Online Comment

Application H02-0017-26
Location Rear of 92 - 94 North Street Crowland Peterborough PE6 0EF
Proposal Erection of 2 dwellings with associated parking

Name Parish Clerk
Address Crowland Parish Council

Date Submitted 13-02-26
For/Against Comments

<b>title</b> <b>PROPOSED SITE PLAN</b>	<b>scale</b> <b>1:250 @ A3</b>	<b>date</b> <b>JUNE 2025</b>
<b>contract</b> <b>UK EQUITY LTD.</b>	<b>revision</b> A 18/06/2025 DRAWING ISSUED B 12/12/2025 REVISED FOR PLANNING C 08/01/2026 RAMP ADDED

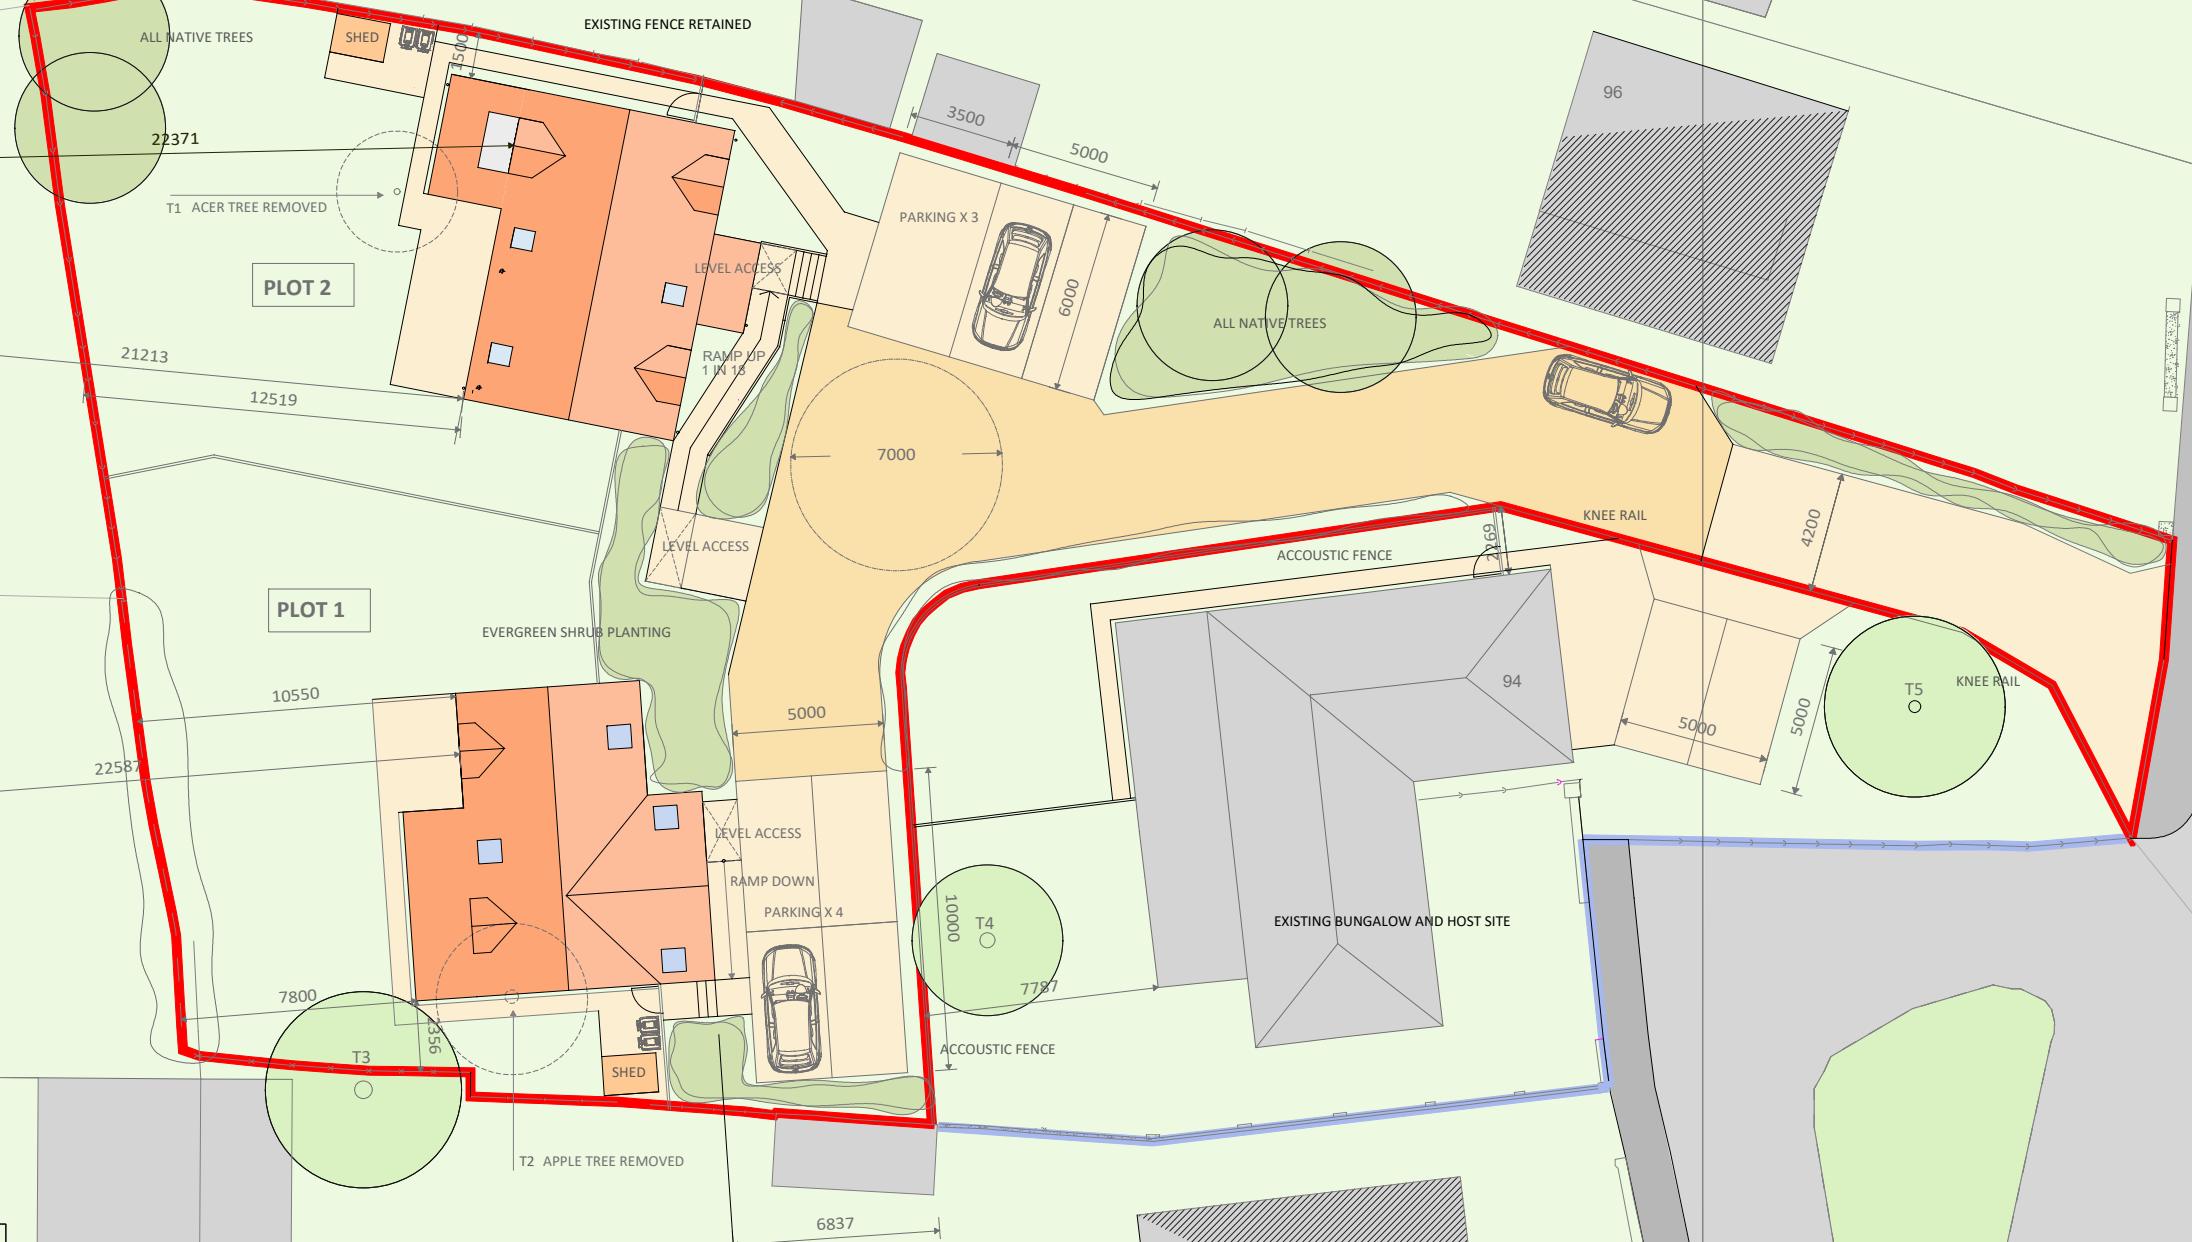
This location already experiences drainage and surface- water issues, and the introduction of additional hardstanding risks exacerbating run- off unless robust mitigation measures are demonstrated. Clear evidence of how surface water will be managed is required. The Council also notes existing parking pressures along North Street and expects the applicant to provide adequate on- site parking provision to avoid further displacement onto the public highway. Assurance is sought that these matters have been fully assessed and addressed within the application.
